**Planning Application Ref:** R/252/17/T

**Location :** Various Locations throughout the Sea Estate, Rustington

**Description of works:** Various Surgery & Felling works as listed in application schedule.

SEA ESTATE RUSTINGTON
 PROPOSED WORK TO TREES WITH PRESERVATION ORDERS (TPO'S)
 2017 - 2018
 REFER TO TABLE FOR SCOPE OF WORK

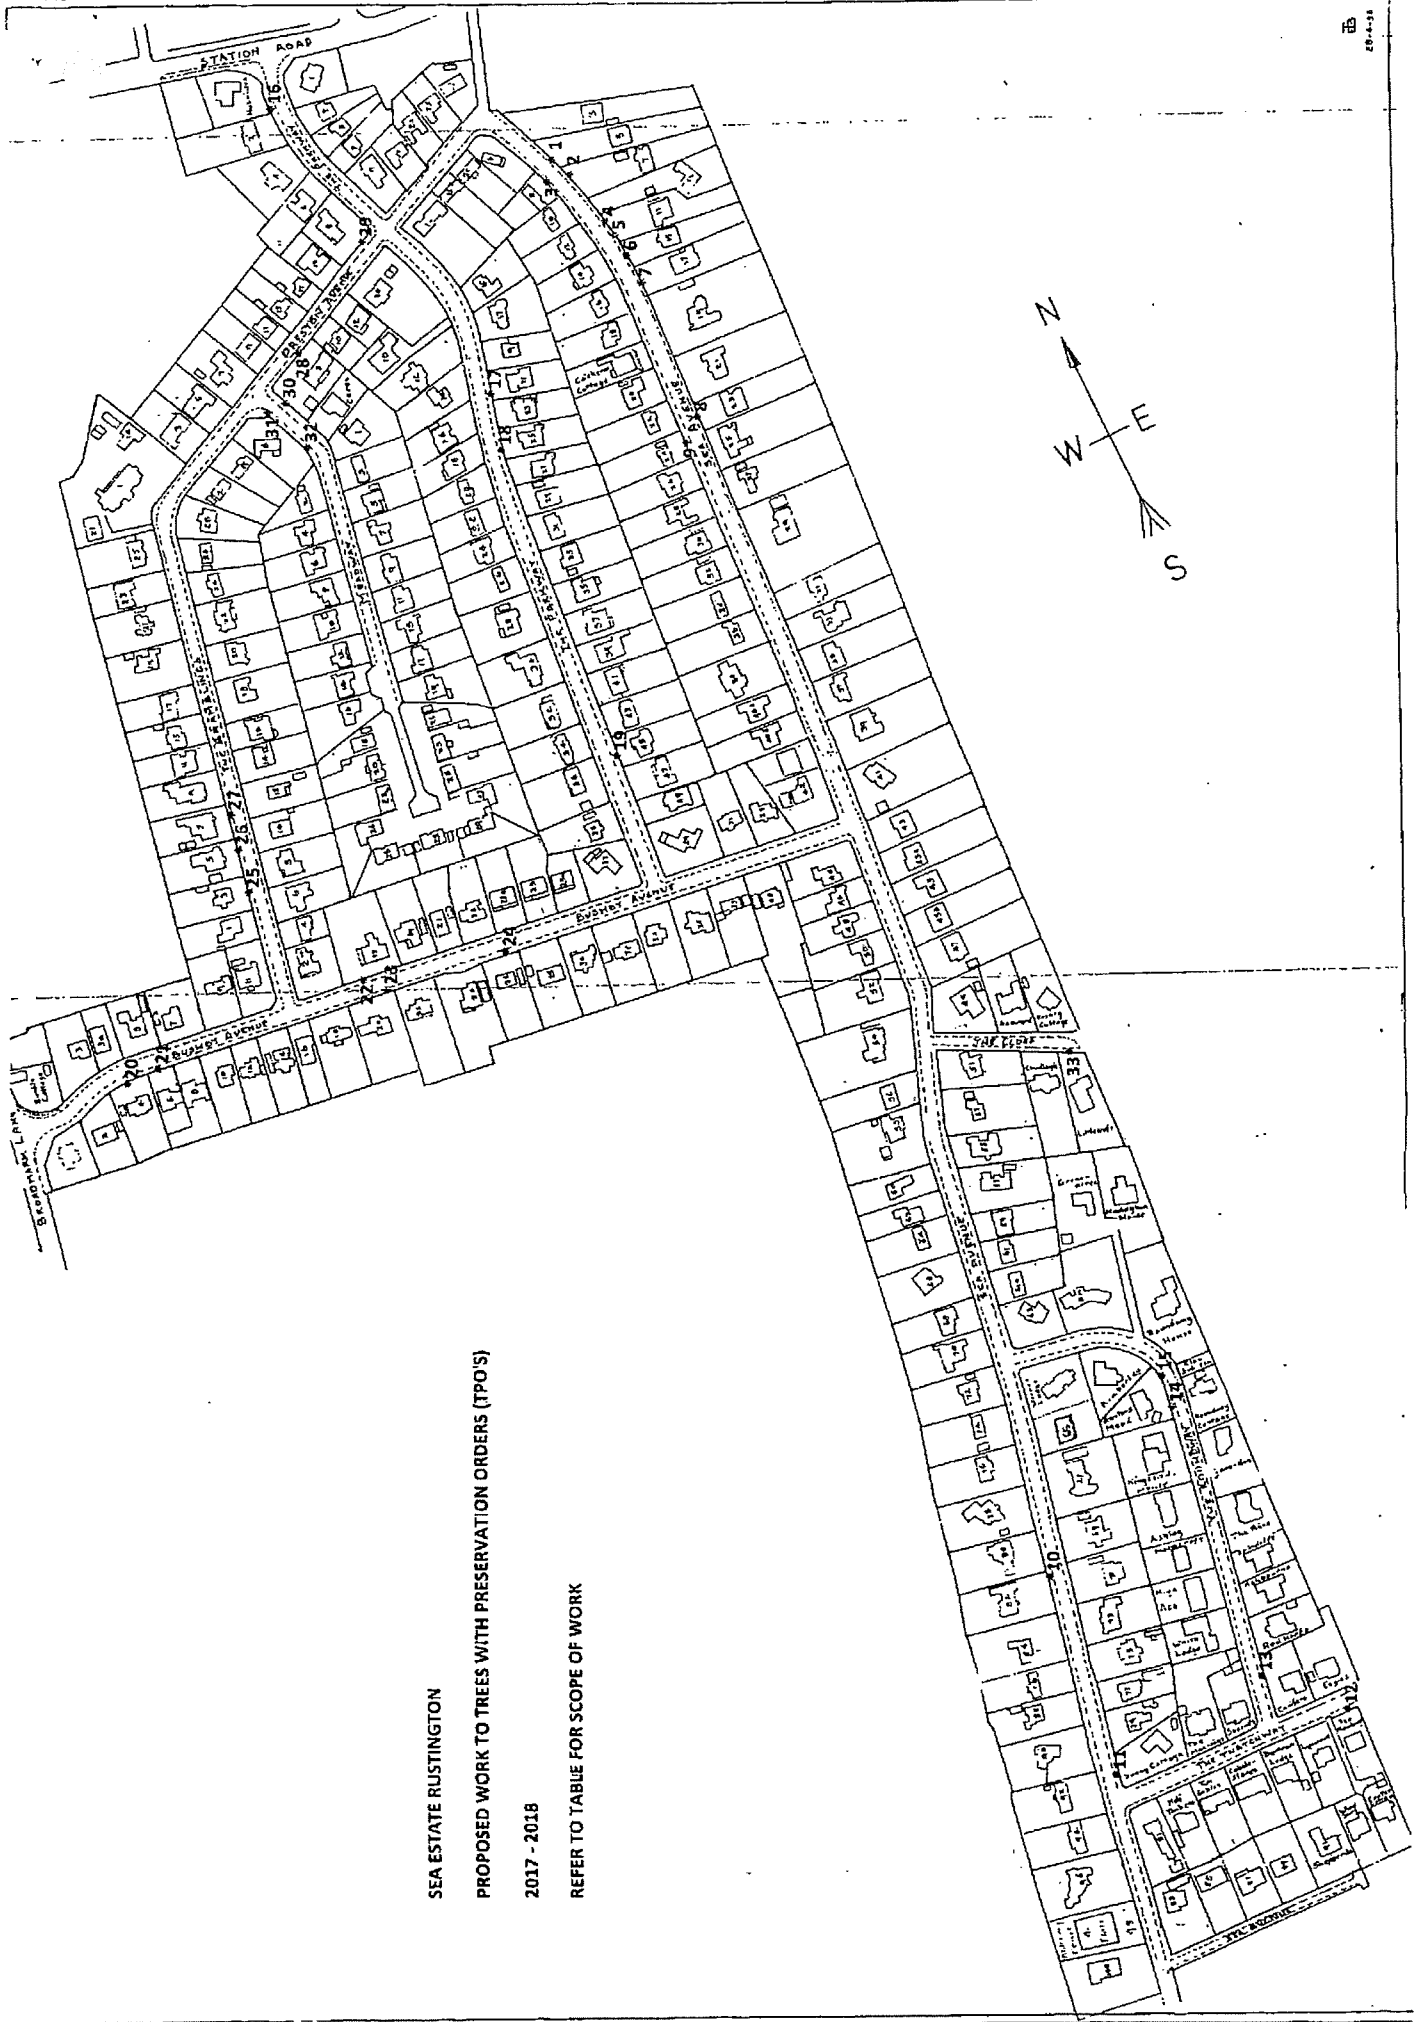
12 – Is listed as an Ash but I only witnessed a Willow and a Tree of Heaven at the location shown on their plan?

28 – It just says crown lift on road side? – we will need them to state to what height above ground and what the maximum diameter of branch is involved.

*8 – Crown lift by removing only the two lowest whorls of branches.*

*9 - Crown lift by removing only the lowest whorl of branches.*

*21 – Crown lift to 4m over road and 2m in all other directions.*

*25 – Reduce the three lowest branches facing west by a maximum of 1m.*

*26 – Reduce the lowest west facing branch by a maximum of 1m.*

*27 - Reduce the five lowest west facing branches by a maximum of 1m.*

*29 – Crown lift to 5m removing only branches up to 4cm in diameter.*

***30 – Crown lift to 3m on road side only by removing branches less than 5cm in diameter.***

***31 – Crown lift to all sides by 2m only removing branches up to 4cm in diameter.***
